REQUEST

Proposed Zoning: CAC-1(CD) (Community Activity Center-1, Conditional)
Approximately 1.4 acres located along the north side of Pineville-Matthews Road and the west side of Arboretum Drive

The petition proposes up to 16,500 square feet of a limited number of uses permitted in the CAC-1 zoning district.

STD. NO.	REV.
60.01A

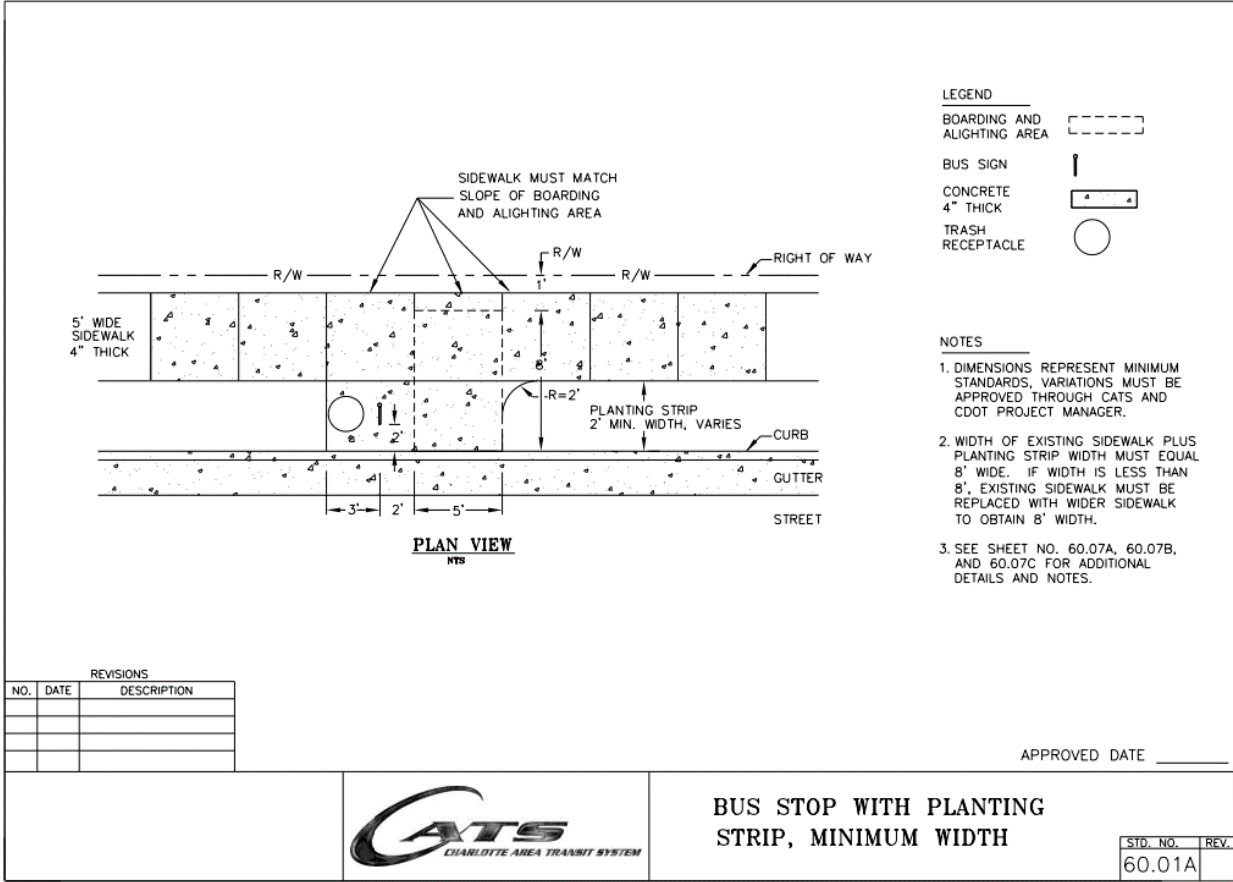
- The proposed rezoning includes limitations on building height and floor area, ensuring that new development will maintain an appropriate scale and character in relation to neighboring properties.
- CATS will require an upgrade of an existing bus stop to an ADA-compliant bus standard detail 60.01A along Pineville-Matthews Rd. The final location will be coordinated with the developer during the Land Development process.
- The petition could facilitate the following *2040 Comprehensive Plan Goals*:
 - 1: 10 Minute Neighborhoods
 - 5: Safe & Equitable Mobility
 - 8: Diverse & Resilient Economic Opportunity

- In accordance with Article 32 of the Ordinance, CATS requires the upgrade of an existing bus stop to an ADA-compliant bus standard detail 60.01A along Pineville-Matthews Rd. The final location will be coordinated with the developer during the Land Development plan review process.
- Primary structure gross floor area shall not exceed 16,500 square feet.
- Building height shall not exceed 50’ as defined by the Unified Development Ordinance.
- **Permitted Primary uses shall be limited to the following:**
 - Animal Care Facility
 - Art Gallery
 - Arts/Fitness Studio
 - Financial Institution
 - Industrial Design
 - Medical/Dental Office
 - Office
 - Personal Service Establishment
 - Retail Goods: Establishment
 - Retail Goods: Showroom
